TO: ICG Homes
ATTN: Will Dodge
PROJECT #: 22-1479(311SR)-A
PAGE: 1 of 1
DATE: February 17, 2025
LOCATION: 311 Serentiy, Fuquay Varina
PLAN REF: Lot 311 Serenity by Dynamic Design Group
Project# 22-1479(311SR)

THE FOLLOWING CHANGE(S) OR PROPOSED CHANGE(S) LISTED BELOW ARE DEVIATIONS OR CLARIFICATIONS FOR THE ABOVE REFERENCED PLANS:

FIRST FLOOR STRUCTURAL PLAN

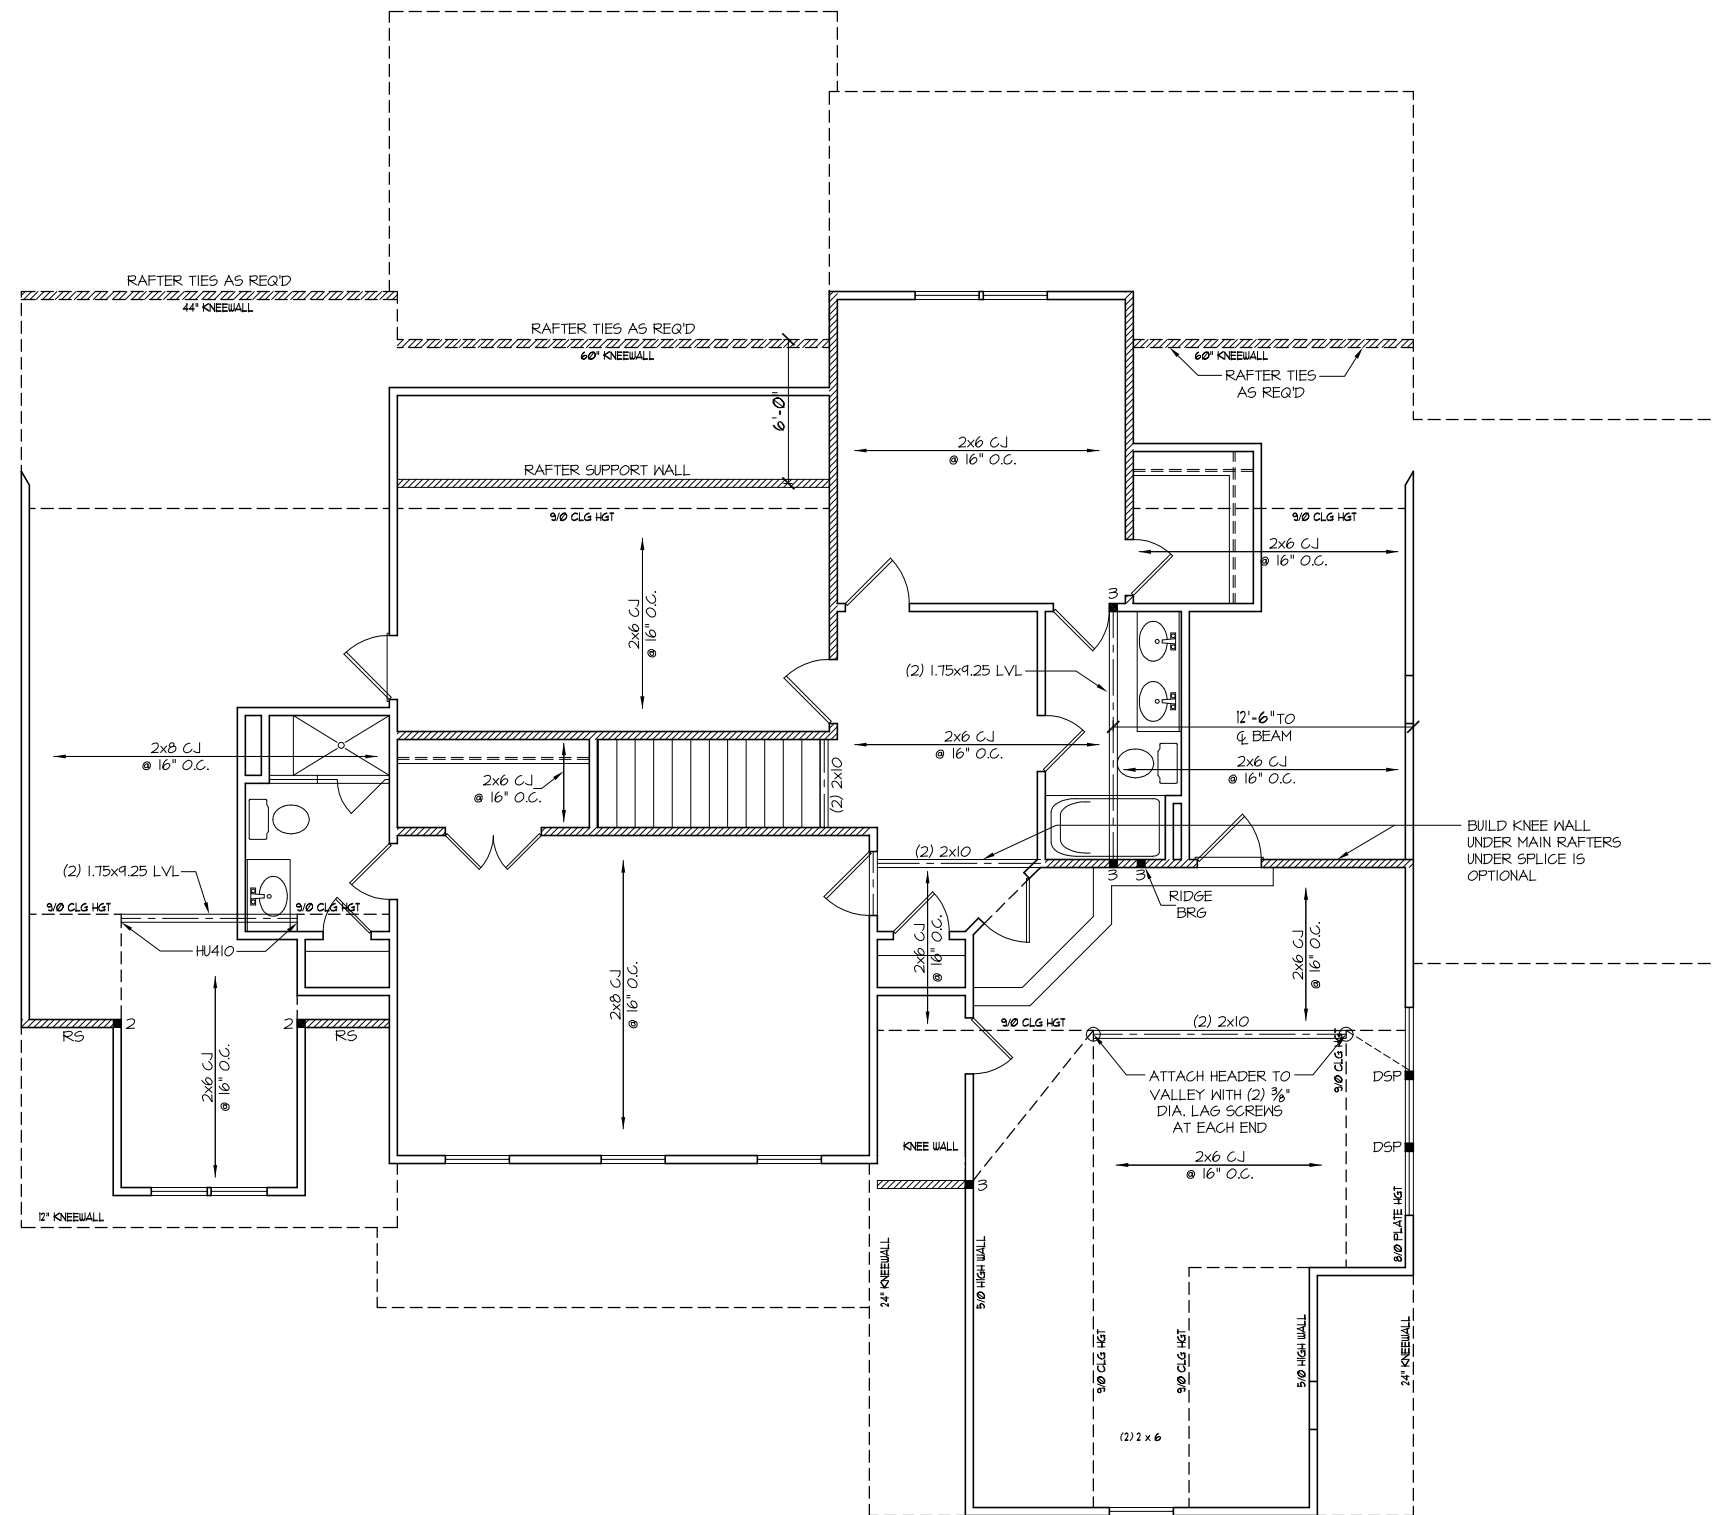
Wall Support: Per information provided by the builder, the I-Joists and (2) 1.75 x 16" LVL were originally designed to be cantilevered to support the offset wall above in Bedroom 3. Please note that it is acceptable to eliminate the cantilever for the I-Joists and (2) 1.75 x 16" LVL, provided a (2) 2 x 6 is added underneath the wall and runs parallel with the 2 x 6 ceiling joists in Bedroom 3. The gap between the (2) 2 x 6 and the offset wall above shall be blocked solid.
